KIRKLEES METROPOLITAN COUNCIL INVESTMENT & REGENERATION SERVICE

DELEGATED DECISION TO DETERMINE PLANNING APPLICATIONS

Reference No:	2025/62/92104/W
Site Address:	50, Birkby Lodge Road, Birkby, Huddersfield, HD2 2BG
Description:	Erection of two storey side extension and extension to existing porch (within a Conservation Area)
Recommending Officer:	Joshua Merriman

Officer Report – 2025/92104

First Floor Layout 1.50

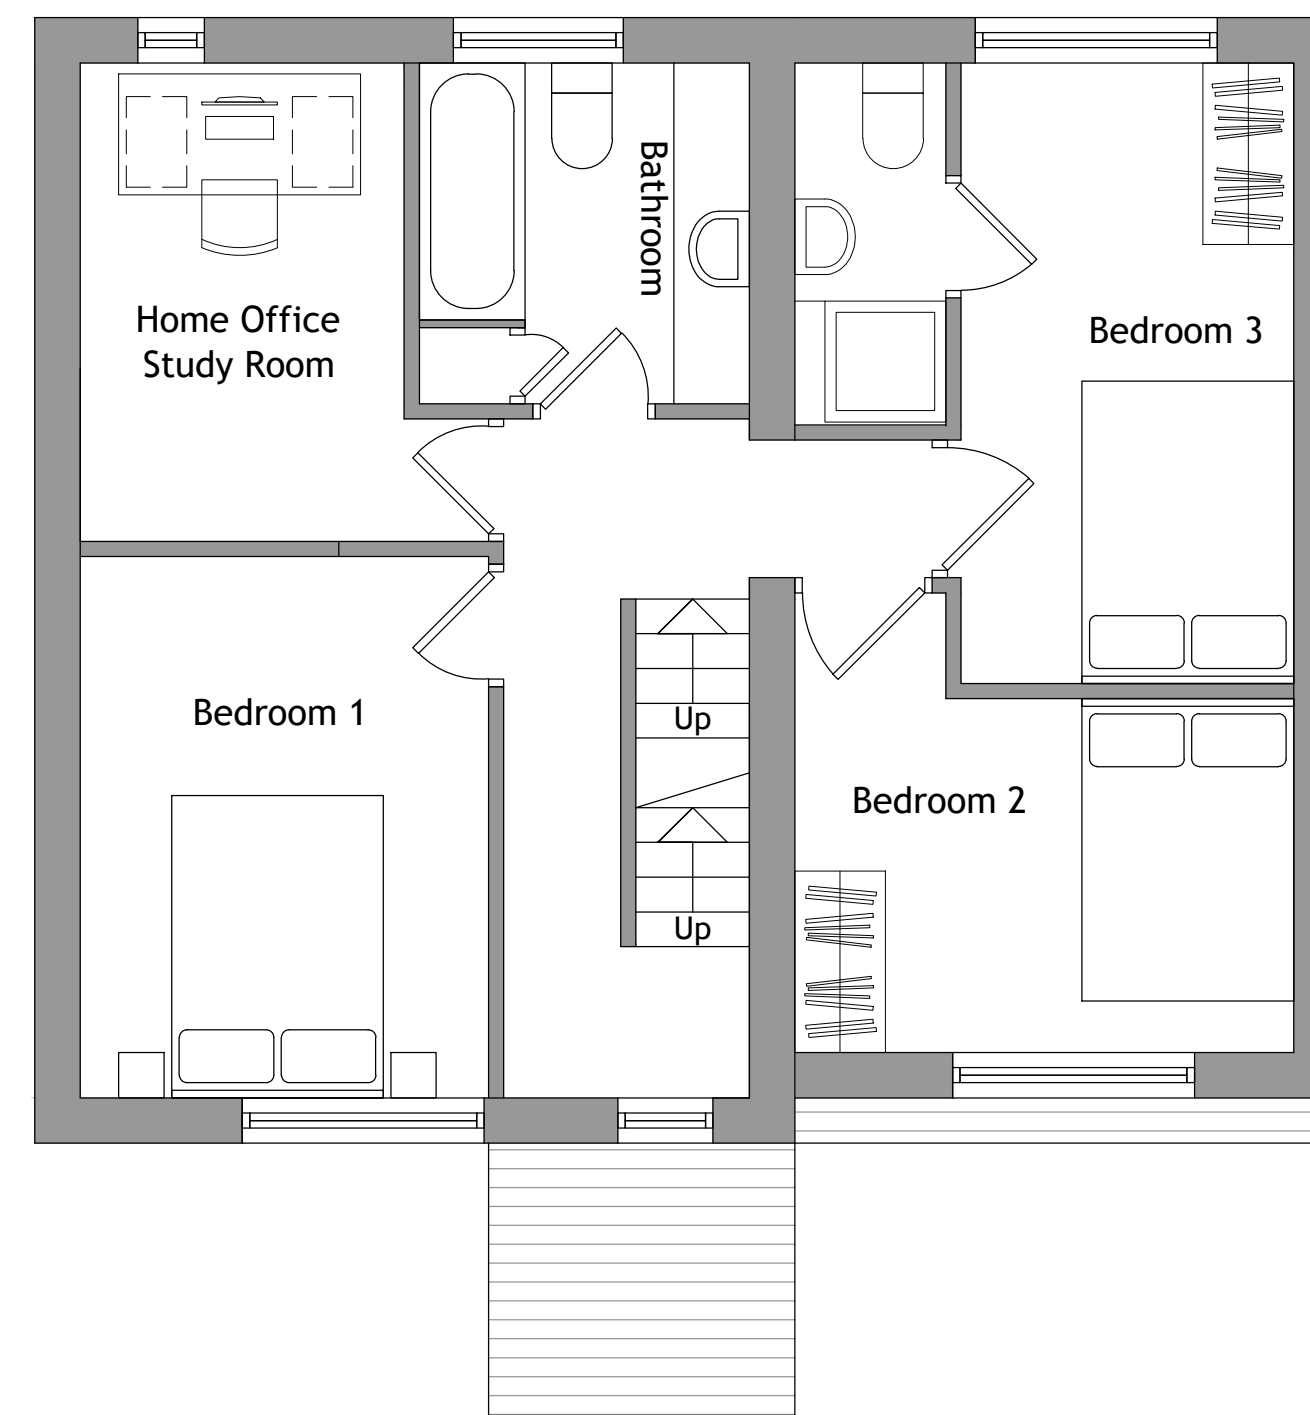
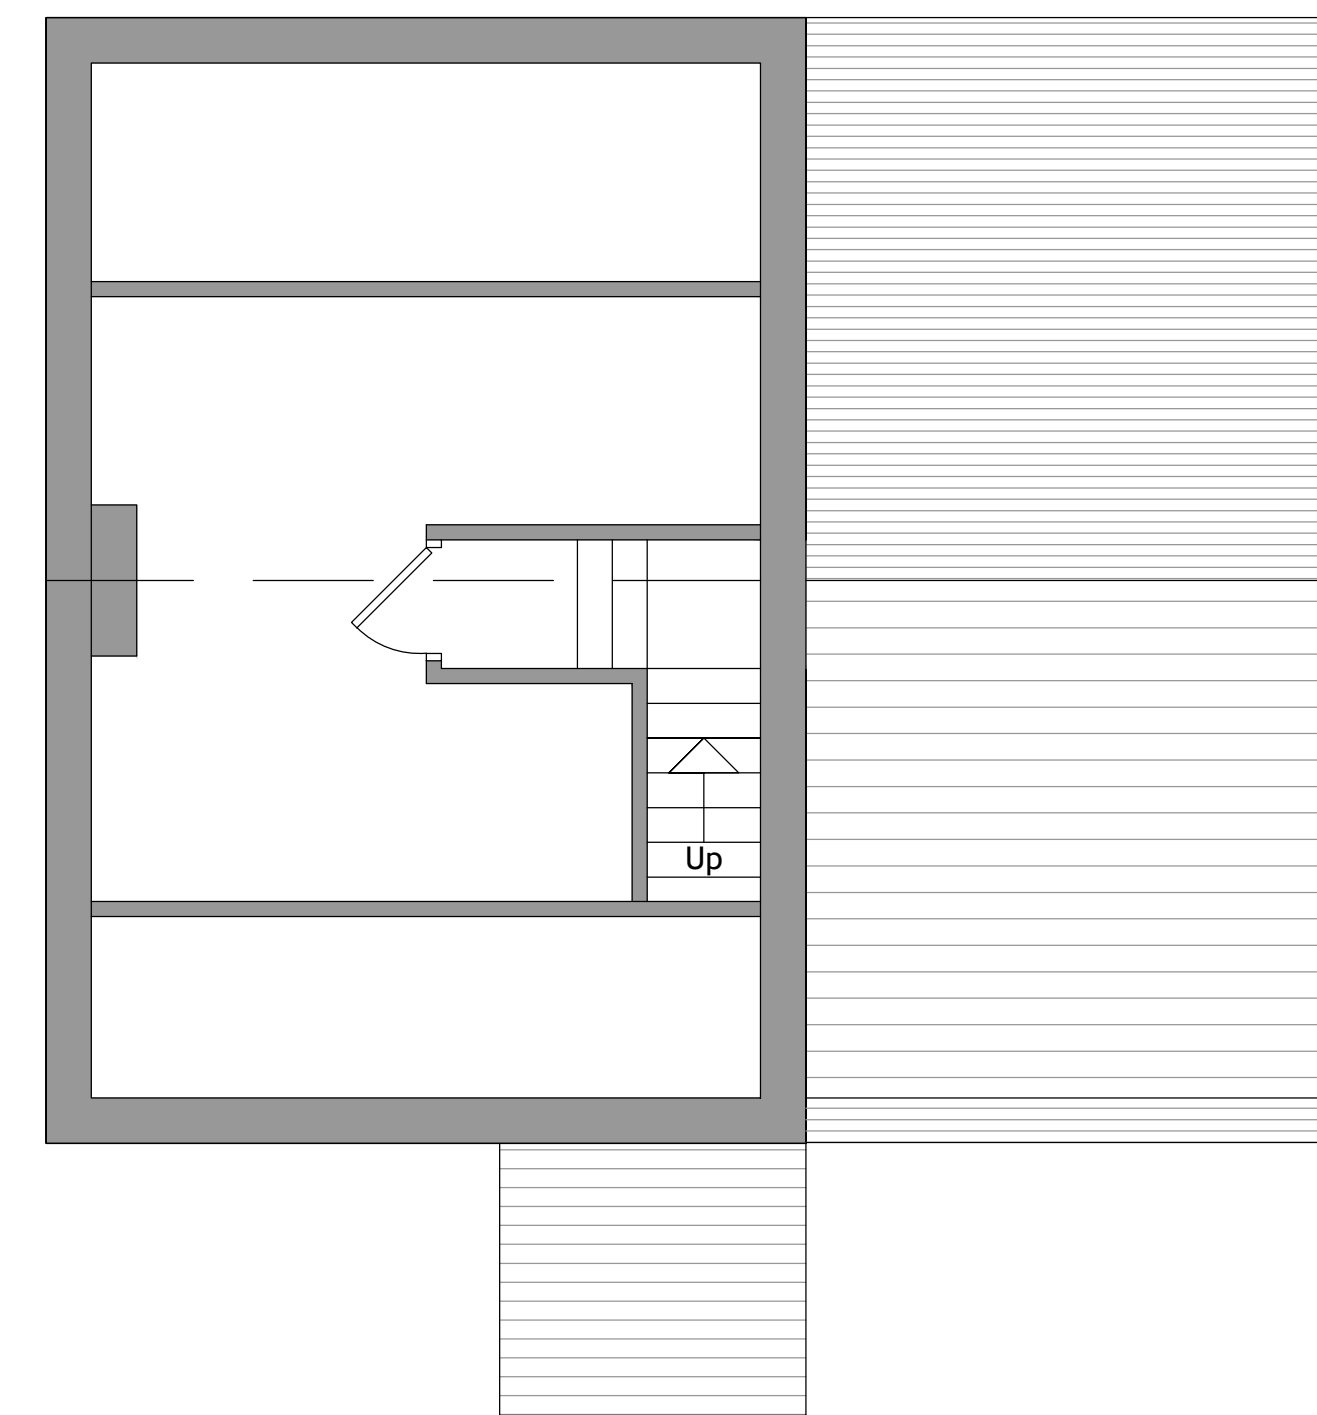
The case officer sought it necessary to set back the side extension and reduce its scale to ensure subservience to the original building, as well as reducing the scale of the front porch so it also remained subservient and only served the original dwelling. Following the receipt of amended plans, it was considered that the development was acceptable.

05/12/2025 – 2224 – 04C Proposed Layout and Elevations
